KITTITAS COUNTY FIRE MARSHAL'S OFFICE

February 23, 2009

Re: Akehurst Re-Zone and Plat

Exhibit "B"

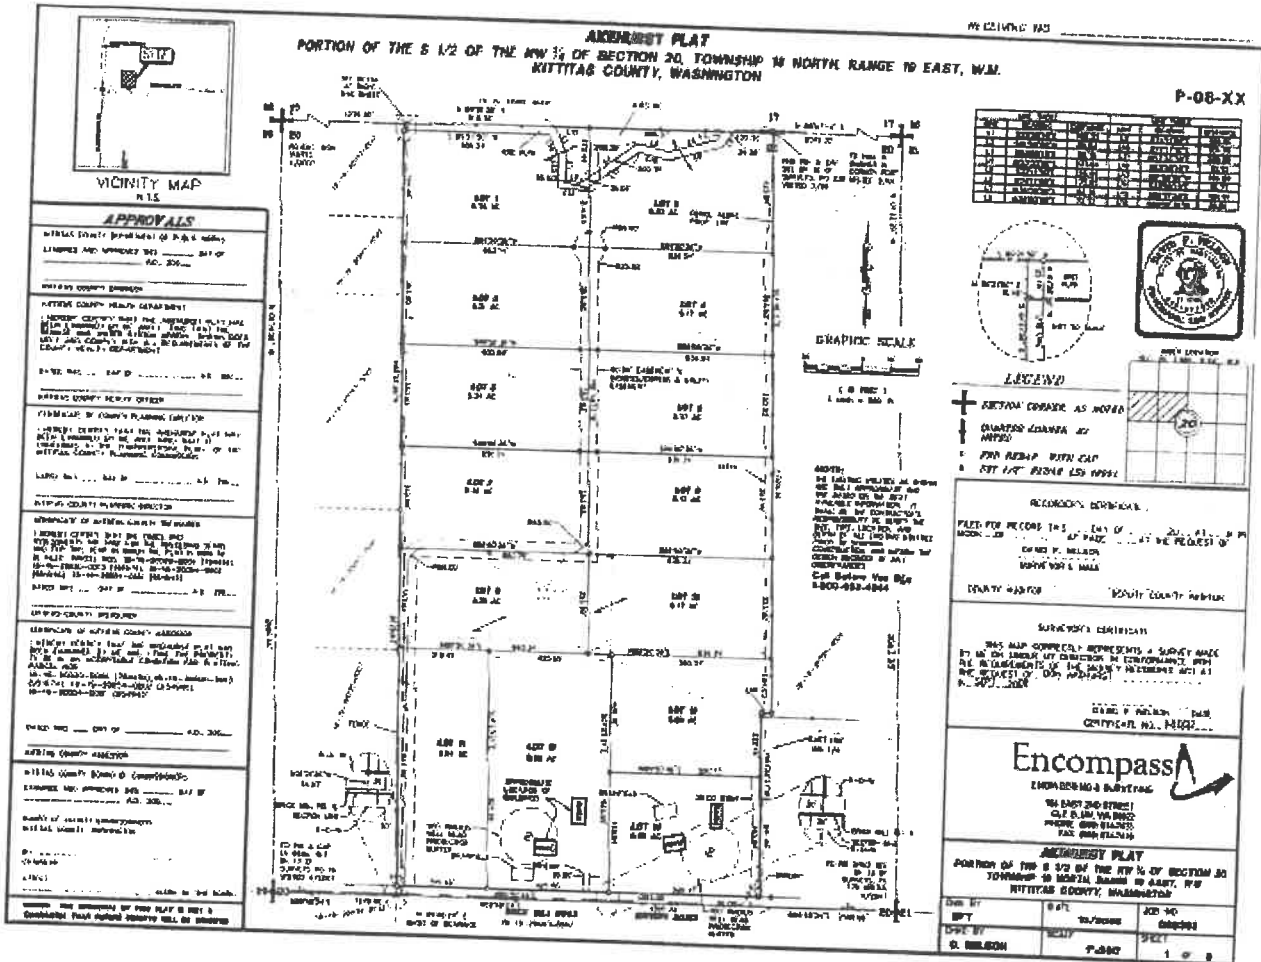
- Given the provided review documents, these residences will require fire flow of at least 1000 gpm (Gallons/Minute) for a duration of no less than 2 hours. A reduction in required fire flow of 50 percent, as approved, is allowed when the buildings are provided with an approved automatic sprinkler system.

- An approved water supply capable of supplying the required fire flow for fire protection shall be provided. A hydrant or standpipe system with an adequate source of water (supply), a distribution system and adequate pressure for delivery shall be installed for this plat. Hydrant spacing shall comply with International Fire Code and its appendices' requirements.

- A separate permit & deposit shall be required for installation of the hydrant or standpipe system.
- Access requirements shall be per the 2006 International Fire Code Appendix D. The turnaround shall have a 70' radius.

- Turnouts may be required along the two north-south portions of the road. Driveways will suffice as turnouts.
